**ADC Planning Consultation
Response from the Historic Buildings Adviser**

Application Number	AB/62/12/L
Address	3 Mount Pleasant, Arundel
Description	Demolition of existing single storey kitchen extension and replacement with single storey extension to provide kitchen, utility and shower room.
Case Officer	James Smith
Site Visit	6 June 2012

Objection

PROPOSED GROUND FLOOR PLAN

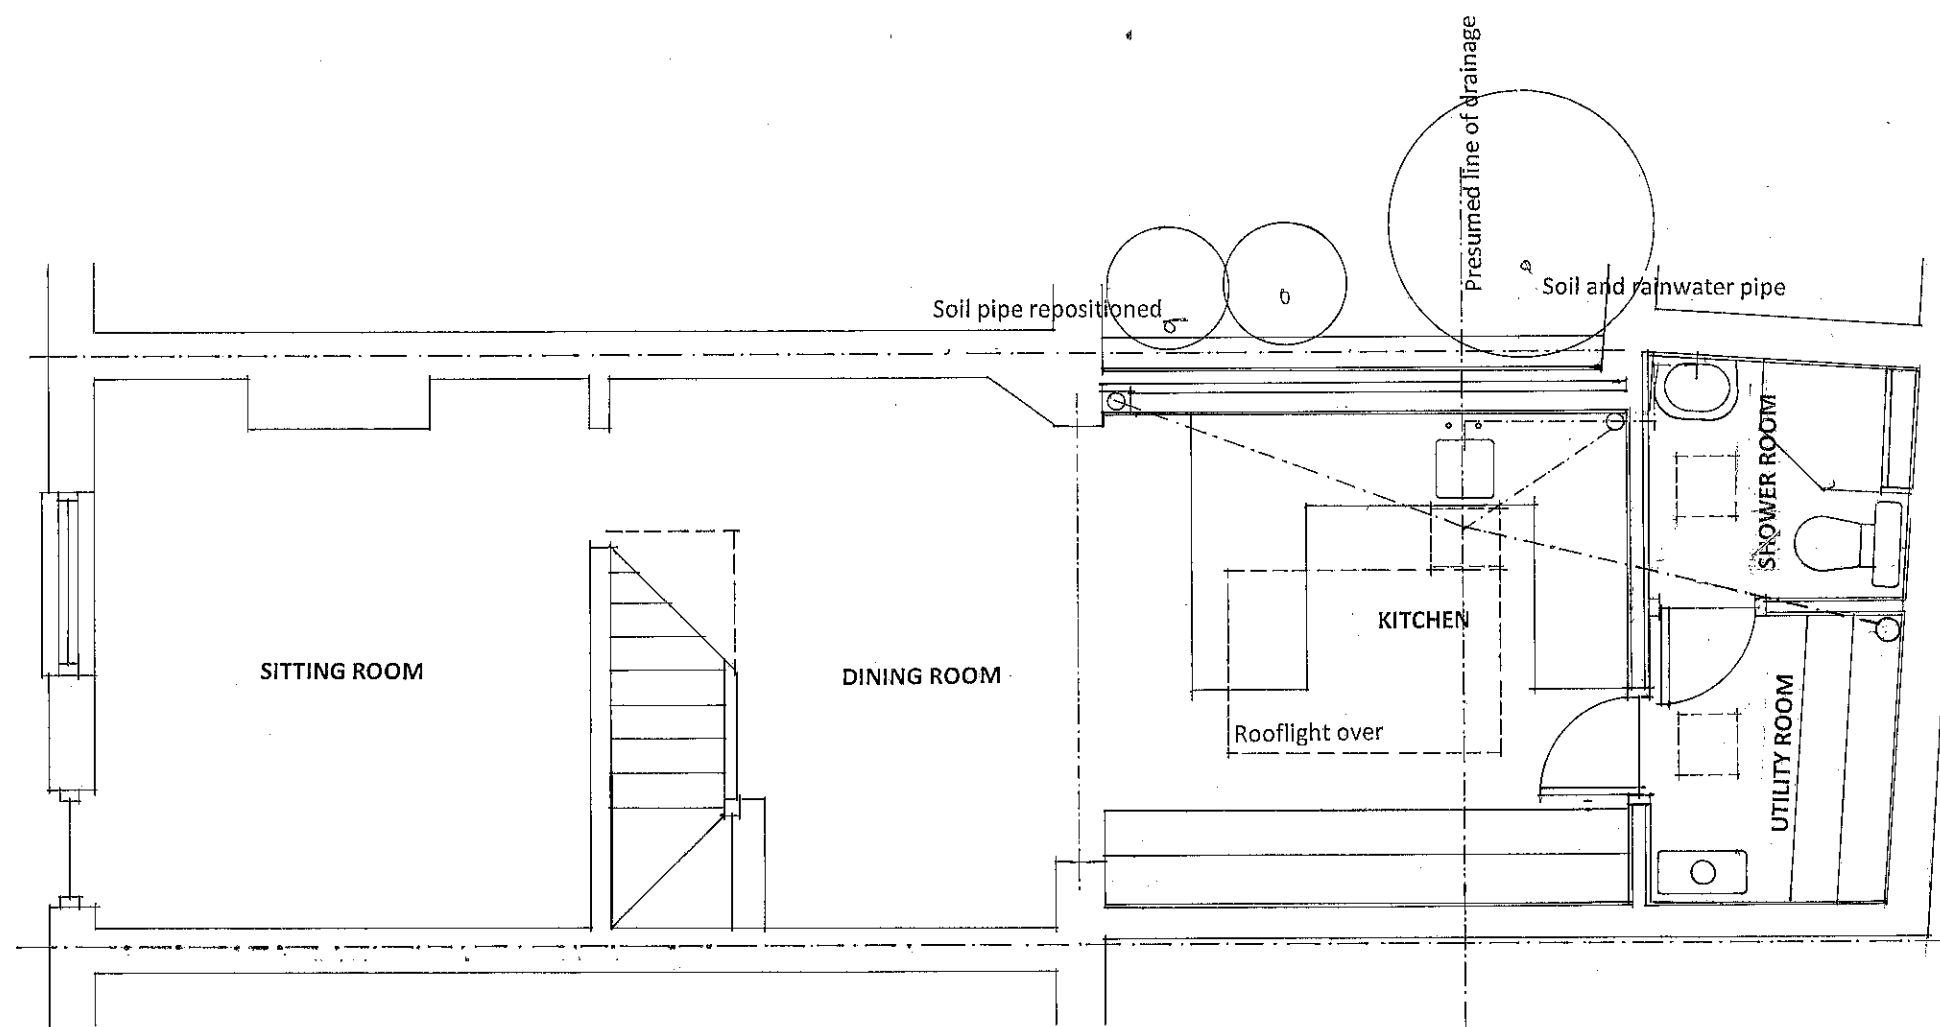
There are two principal concerns with this scheme. The first is the removal of the rear ground floor wall and the second is the infilling of the garden with an increased extension.

The removal of the external wall is extremely problematic, not least because it involves an excessive loss of historic fabric from the main body of the listed building. This contravenes para. 179 of English Heritage guidance for PPS5 (still valid under the NPPF), which stipulates that:

Related to this is the partial loss of the plan which is eroded by the loss of the wall and the total opening up of the internal space. Whilst this is not a complex floor plan, its scale and modesty reflects the character of the building and the nature of its function as a small dwelling. The scope of the breach ignores this as well as results in the loss of original openings. Given the small scale of the building, this harm is considered significant and should be resisted. Para 182 of the same guidance clarifies that:

EXISTING SECTIONS AND ELEVATIONS

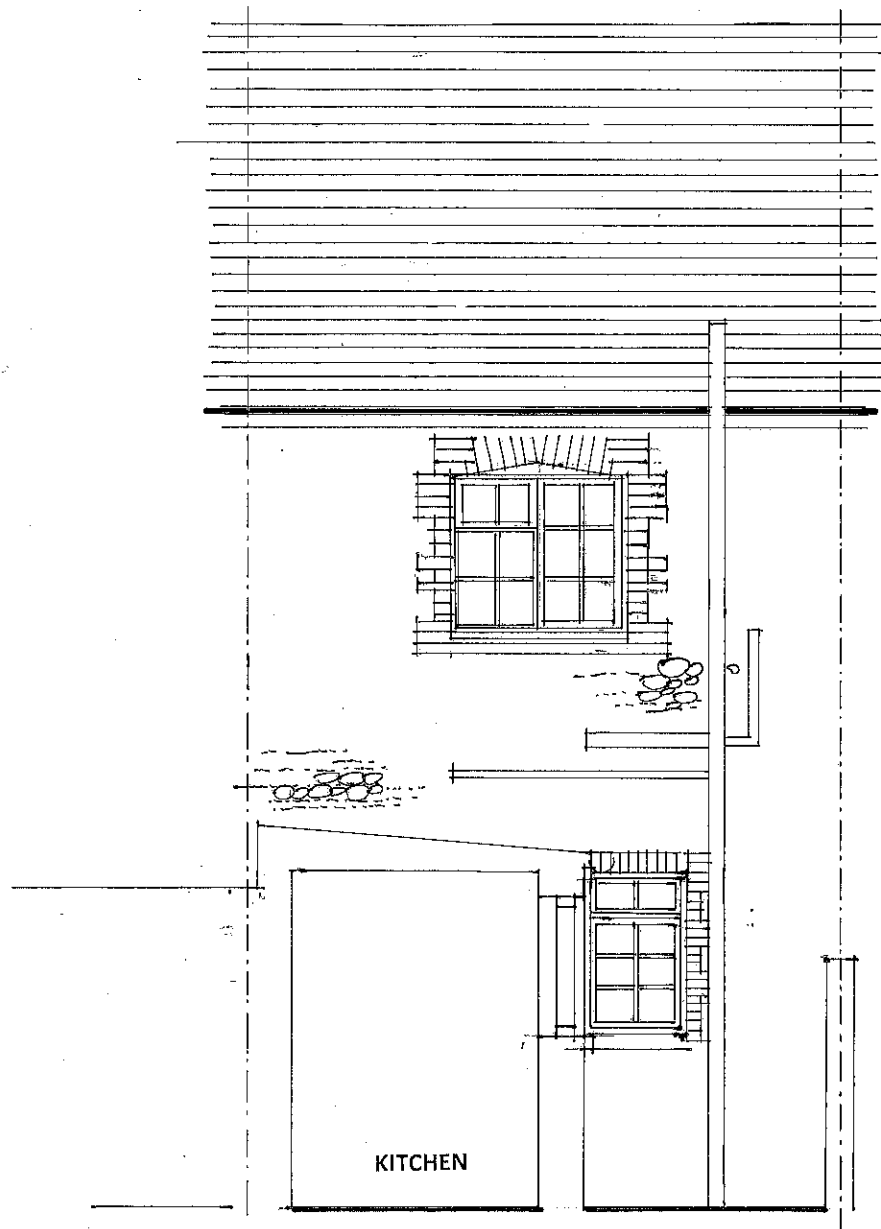
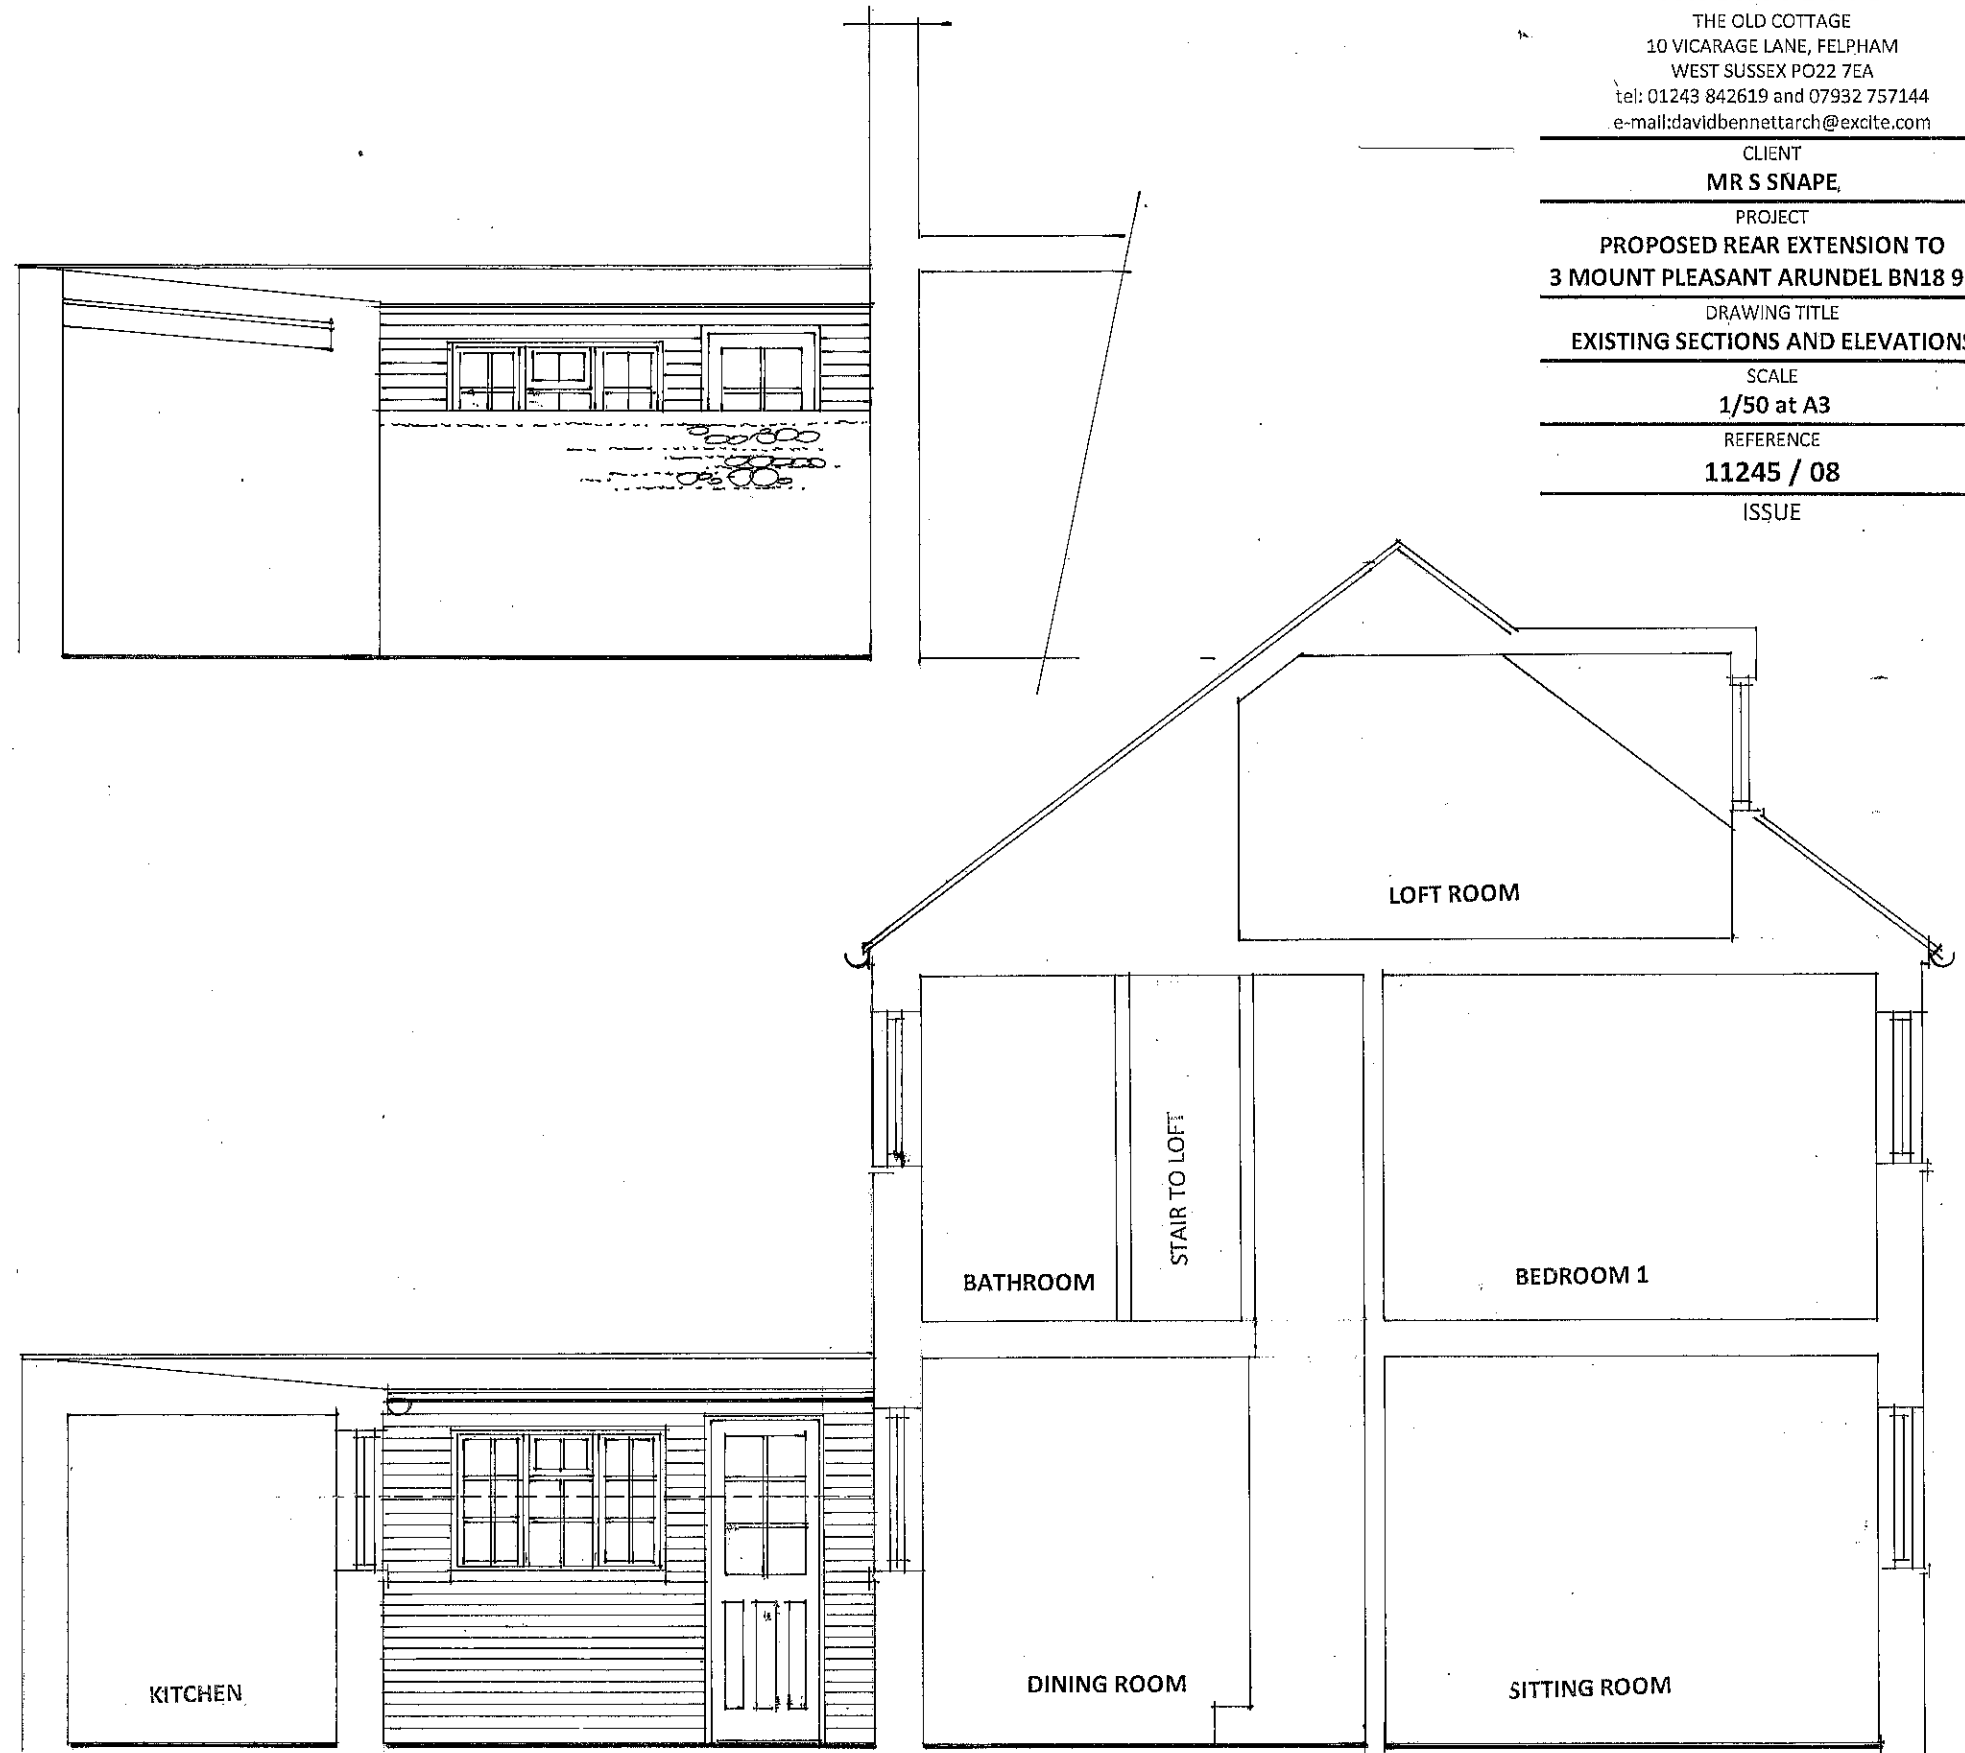
on the existing mono-pitch roof, but as shown in the 'existing' drawing, does not appear accurate. The pitch seems to be greater than that shown and in reality covers more of the rear elevation. A drop in the roof level here would be considered positive.
